From: Richard Castro-Parker <Richard.Castro-Parker@arun.gov.uk>
Sent: 30 January 2019 12:38
[REDACTED]
Cc: Daniel Vick <Daniel.Vick@arun.gov.uk>
Subject: AL/88/18/PL

Firstly I apologise for the lack of contact regarding your clients application ref: AL/88/18/PL – Aldingbourne Cottage Rest Home. I have discussed the application today with the Area Manager and note the following:

PROPOSED FIRST FLOOR

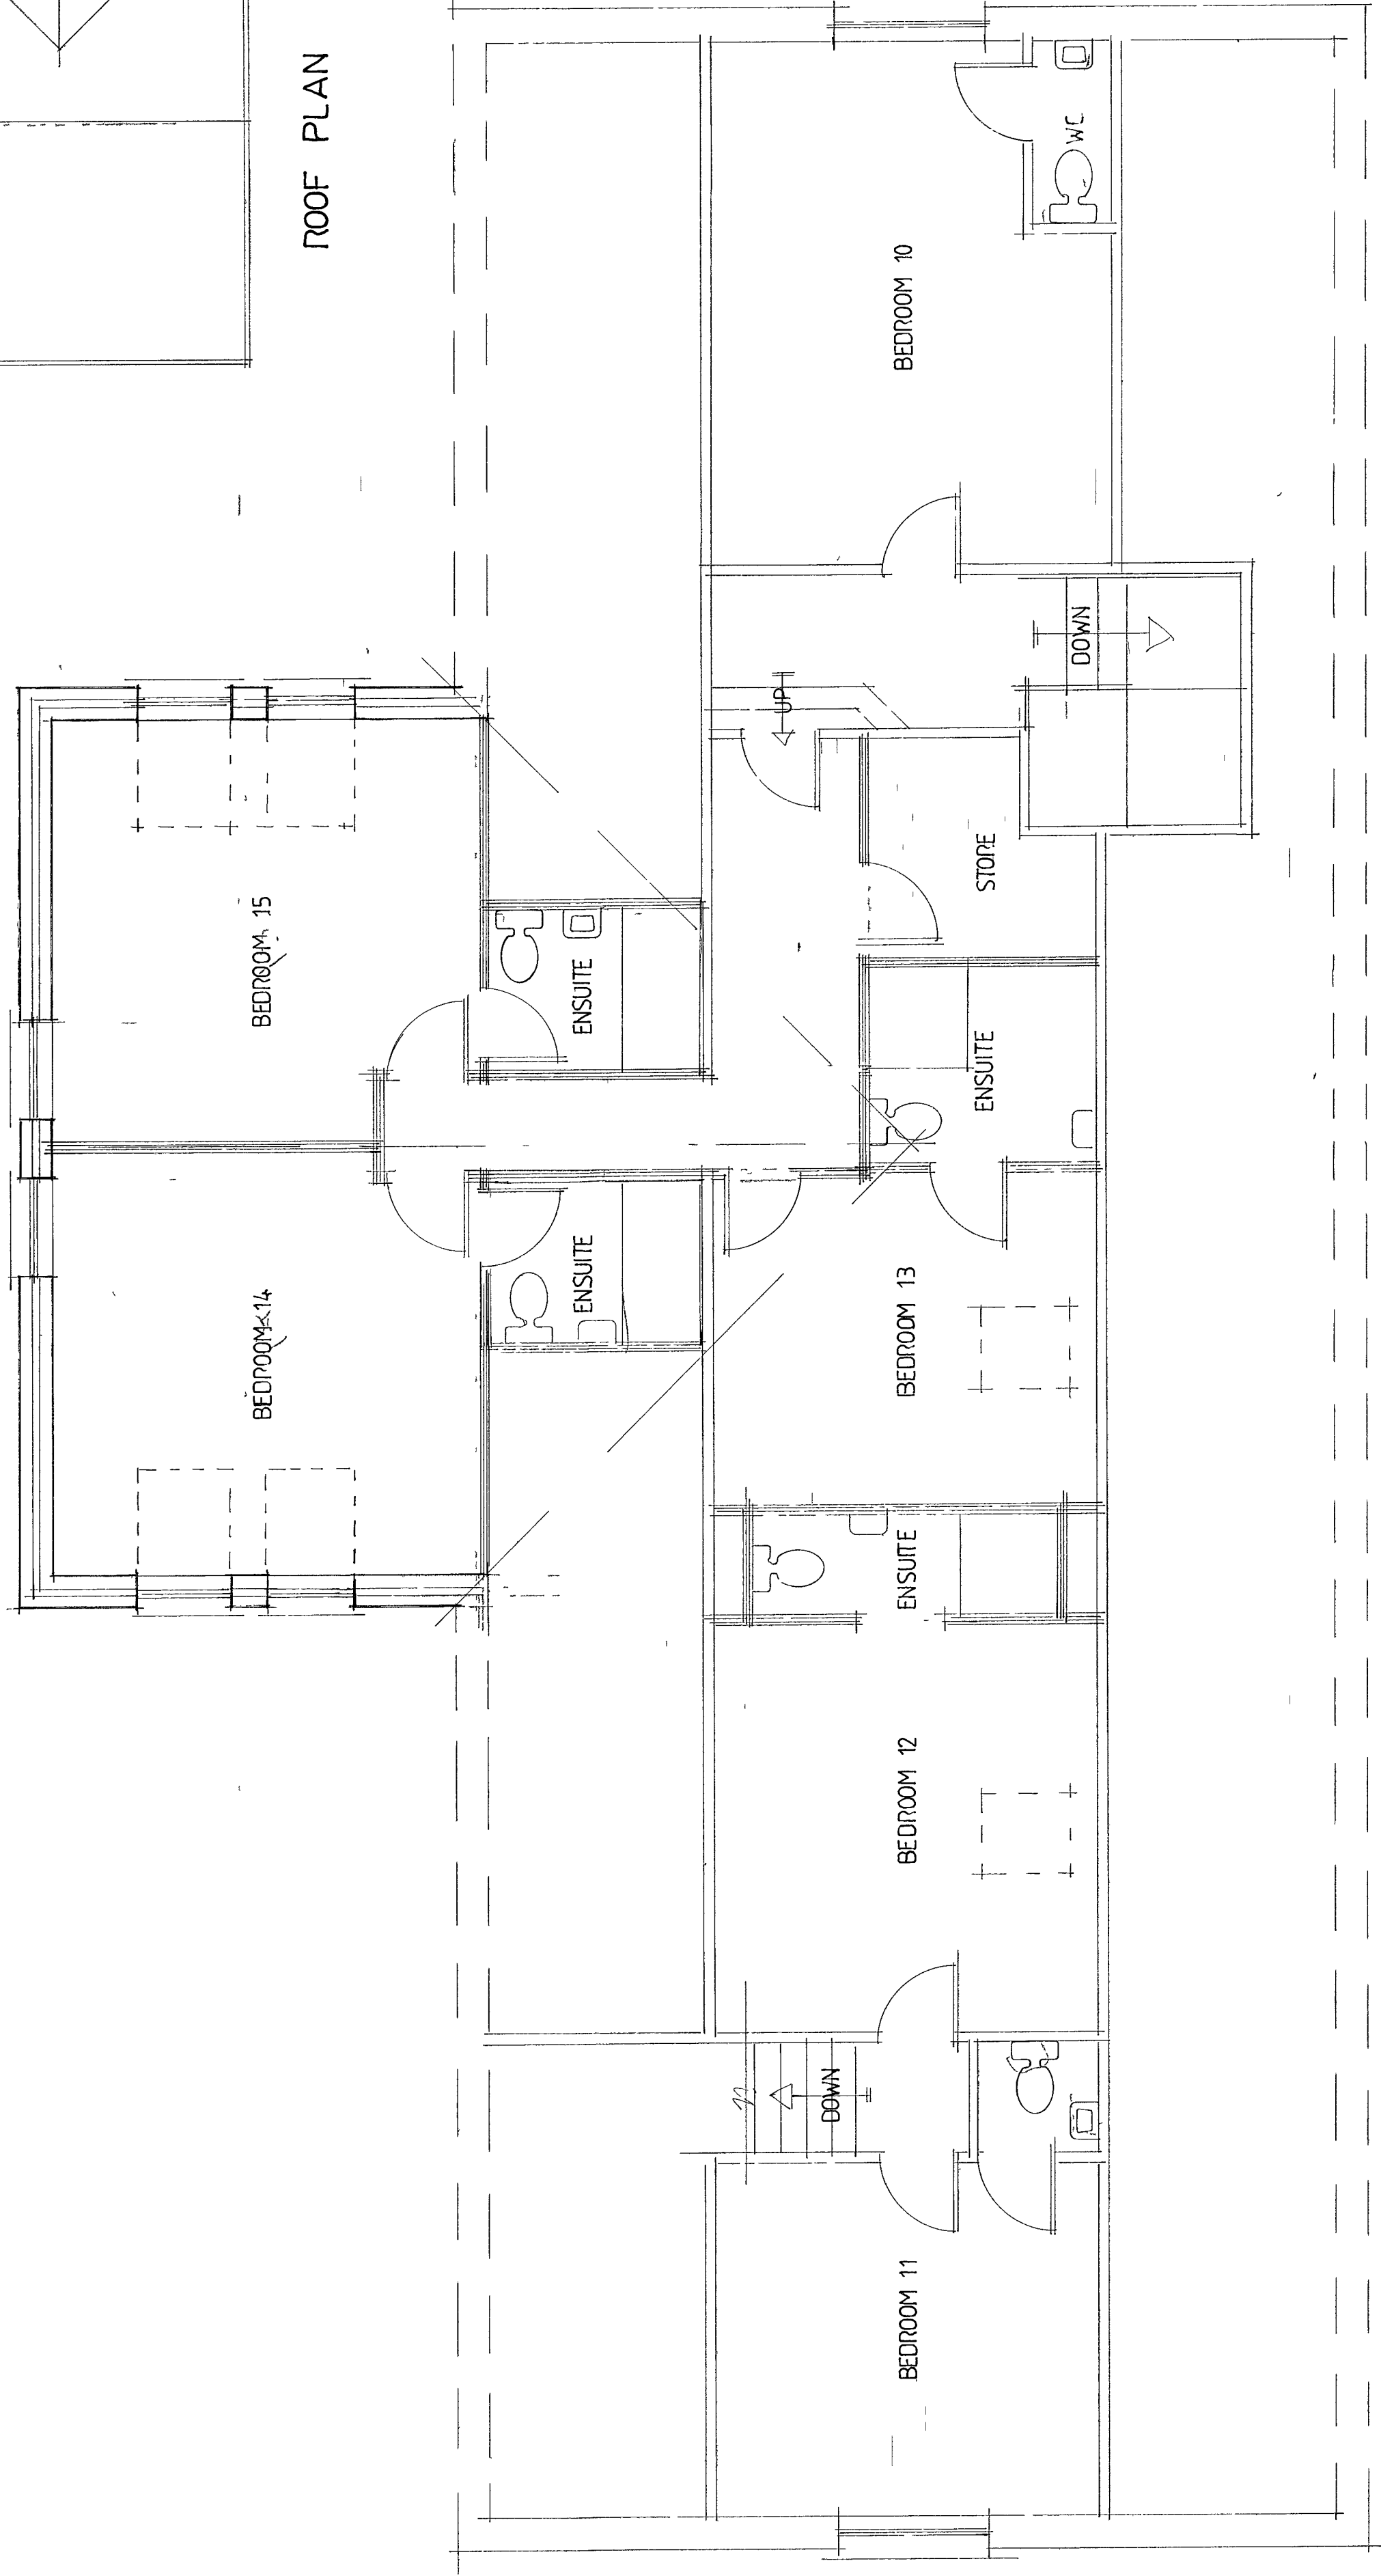
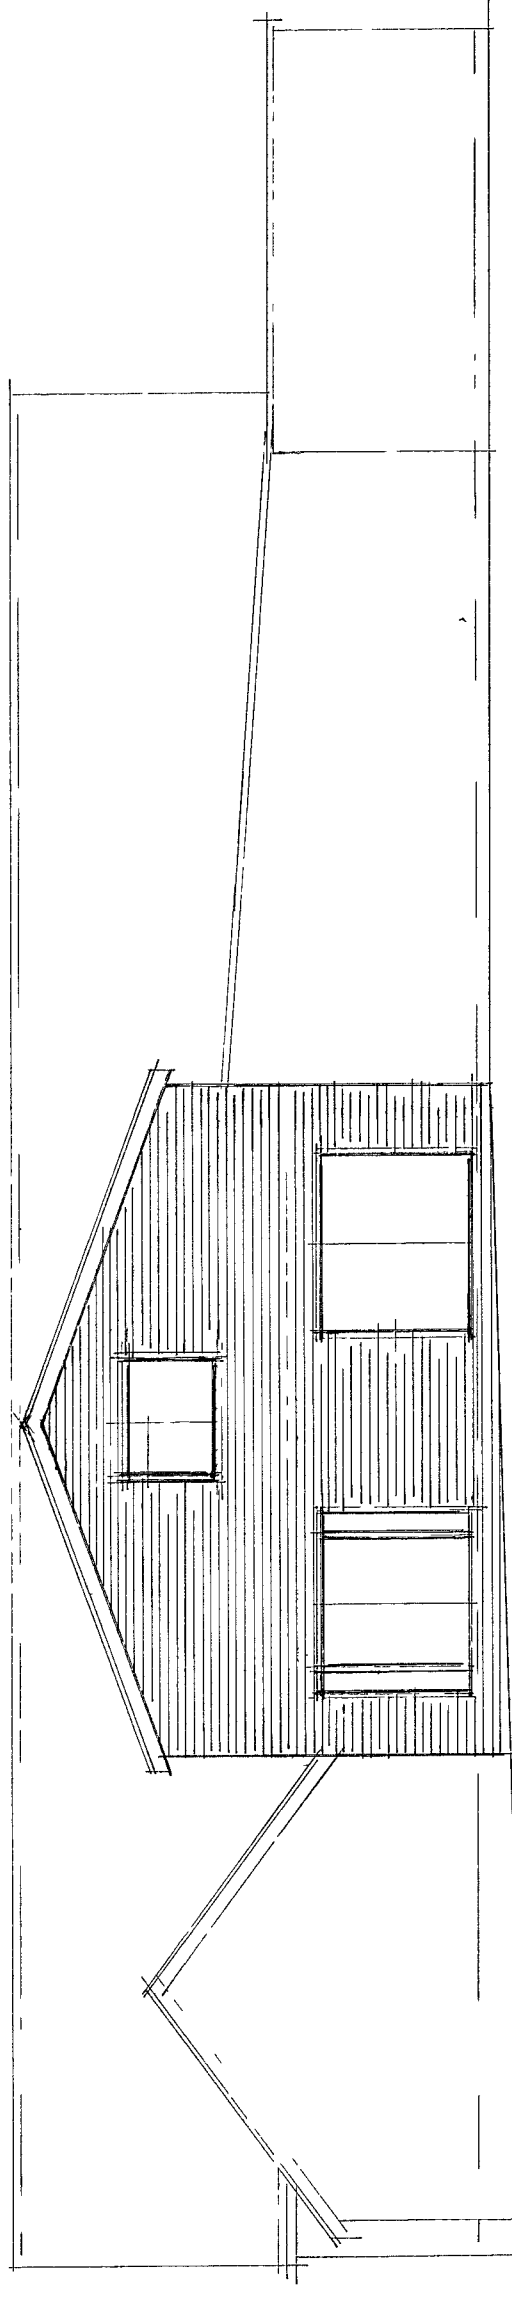
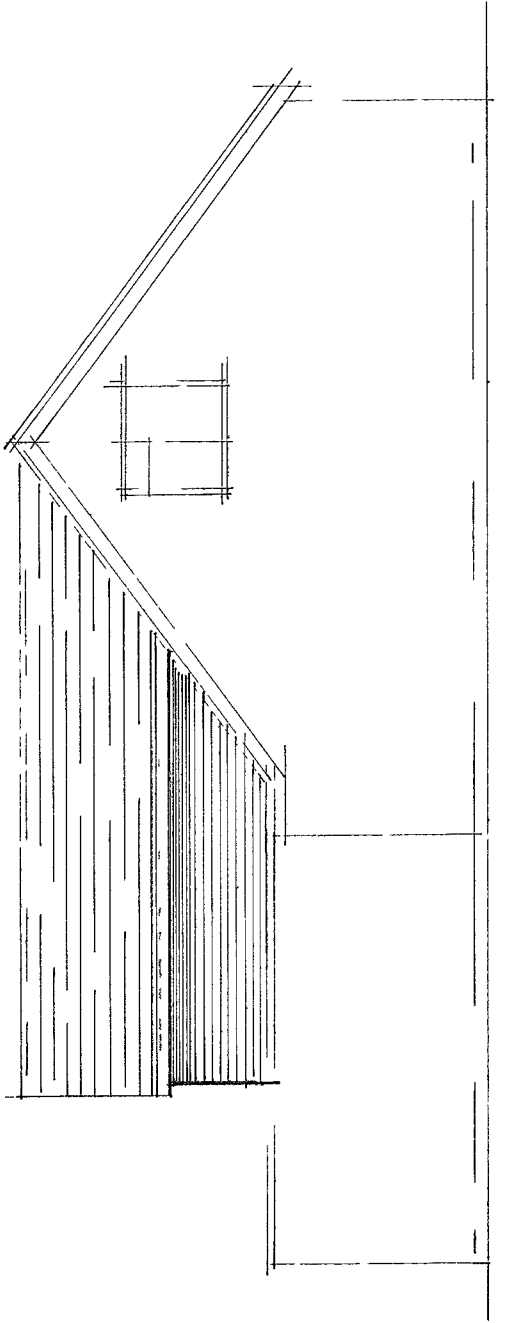
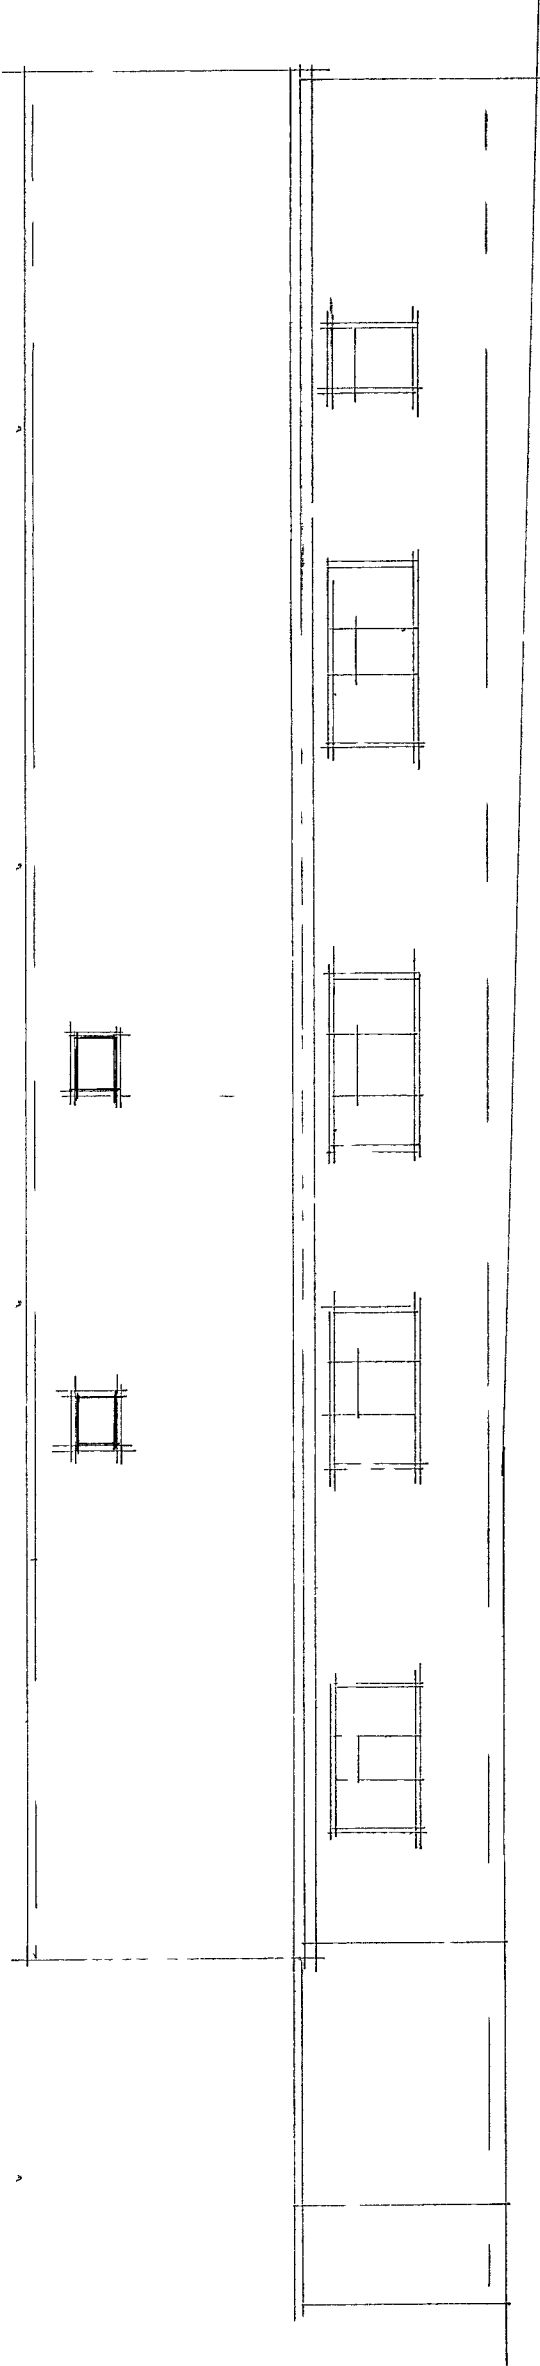
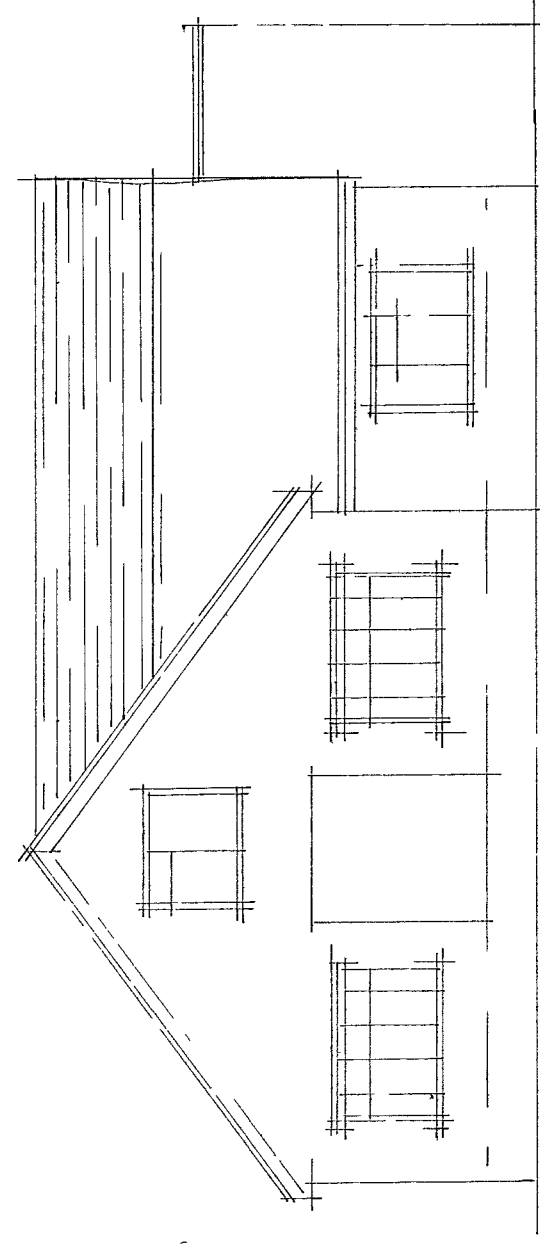
1. It is considered that there would be detrimental level of overlooking from the proposed first floor level windows in the rear elevation of the proposal facing adjoining property 5 Elmcroft Place. Officers note the neighbour comments raised from the Occupiers of 5 Elmcroft Place (this can be viewed on the council's website). Officers could impose a condition to obscure these windows but would not necessarily wish to do so if they are the only windows serving the bedrooms. (see point 2 below).

2. The plans seem to show a number of windows in the side elevation of the extension at first floor level but these are not shown on the side elevations. Please could this be confirmed. If the plans are meant to show windows within the side elevation/roof slope please could the plans be amended accordingly.

1. Our client would be happy to fit obscure glass to the side windows if necessary
2. The plans have been amended to correctly reflect the position of the windows – attached
3. With regards to the tree, the extension is an infill of the existing building and therefore any building works carried out will not affect the tree in question. All shrubs and trees will be unaffected. Any building works carried out will not be detrimental to the surrounding shrubbery.
